KITTITAS COUNTY FIRE MARSHAL'S OFFICE

February 23, 2011

Re: Kukes (BL-11-00002)

After conducting a review of the above named project, I have the following comments:

PROPOSED

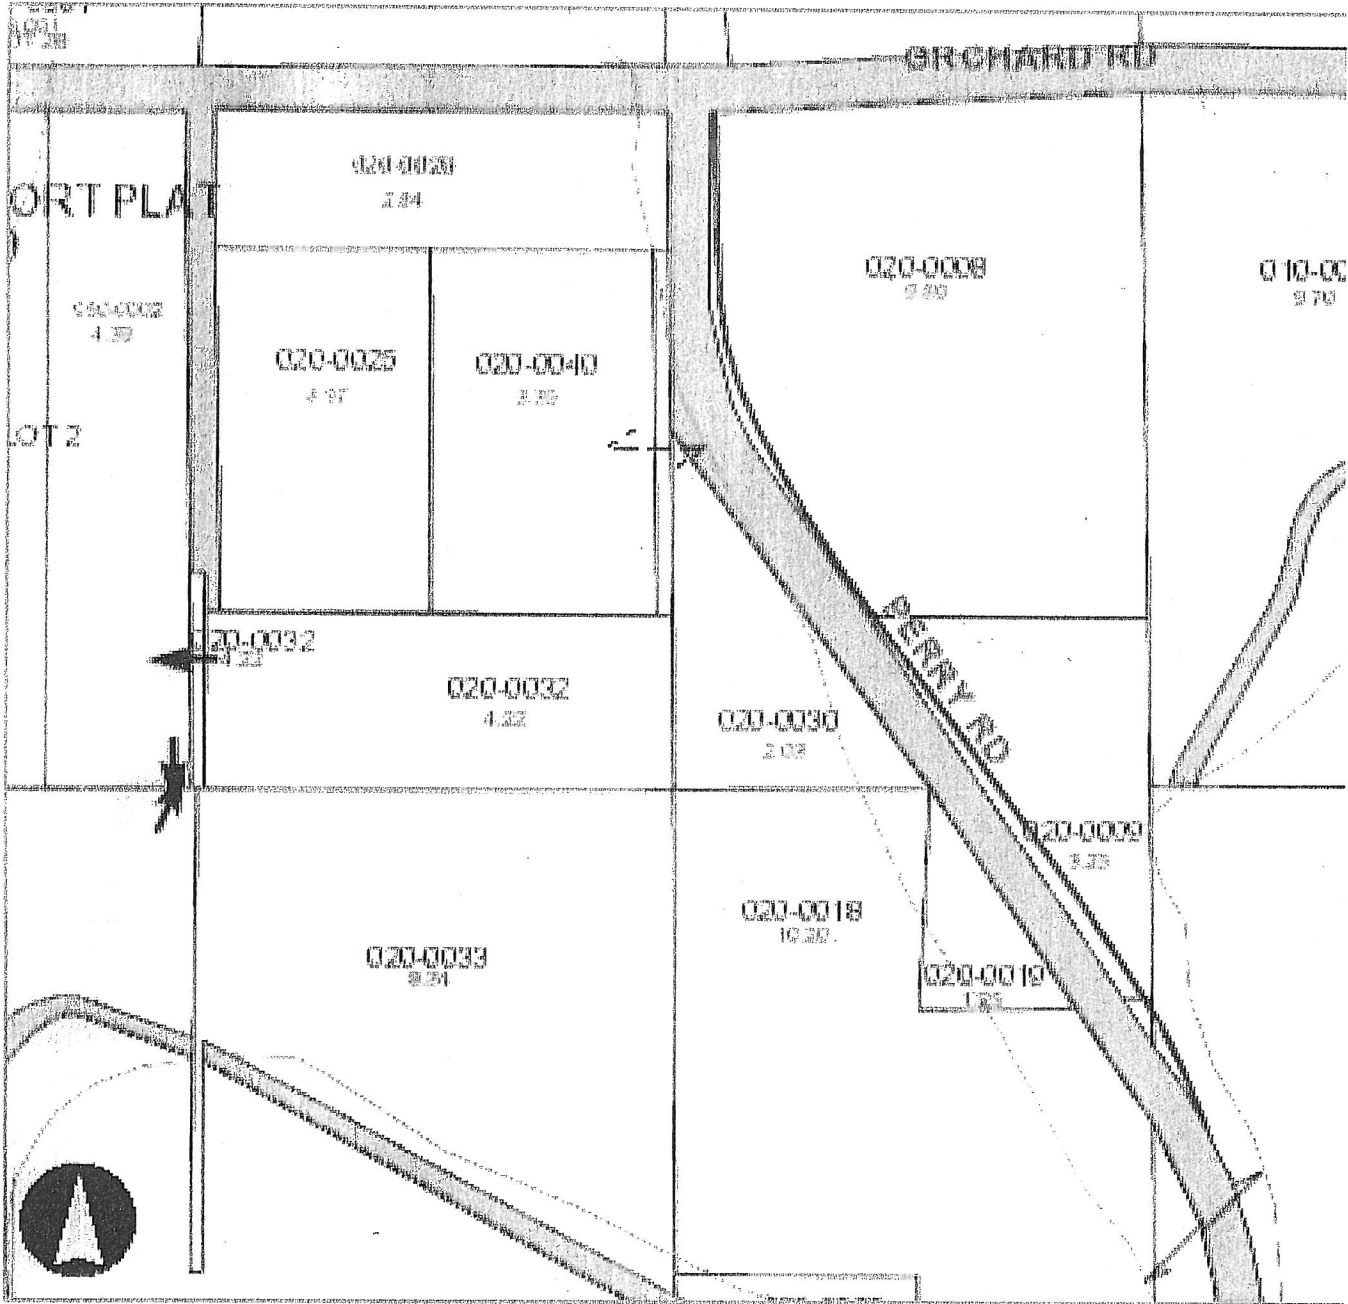
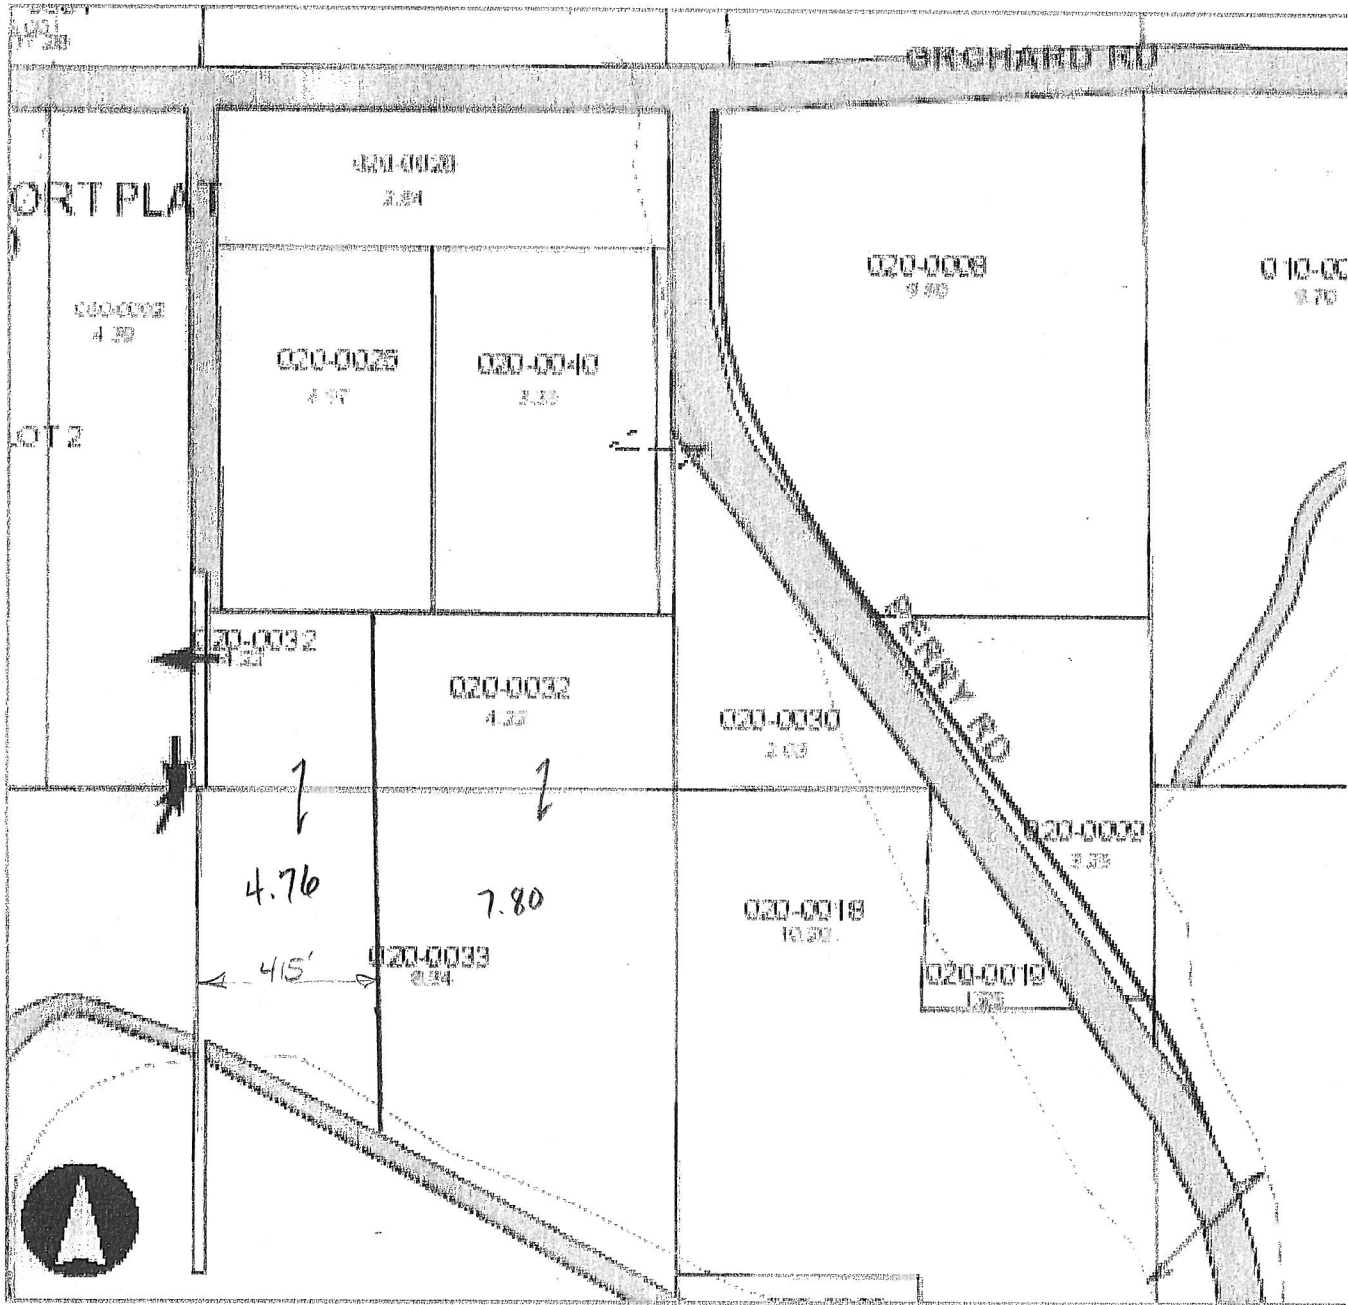
- Ensure that boundary line adjustments do not infringe upon existing structures, to include propane tanks, etc.
- Creation of any additional roads or access must comply with the International Fire Code.
- All future development must comply with the International Fire Code.
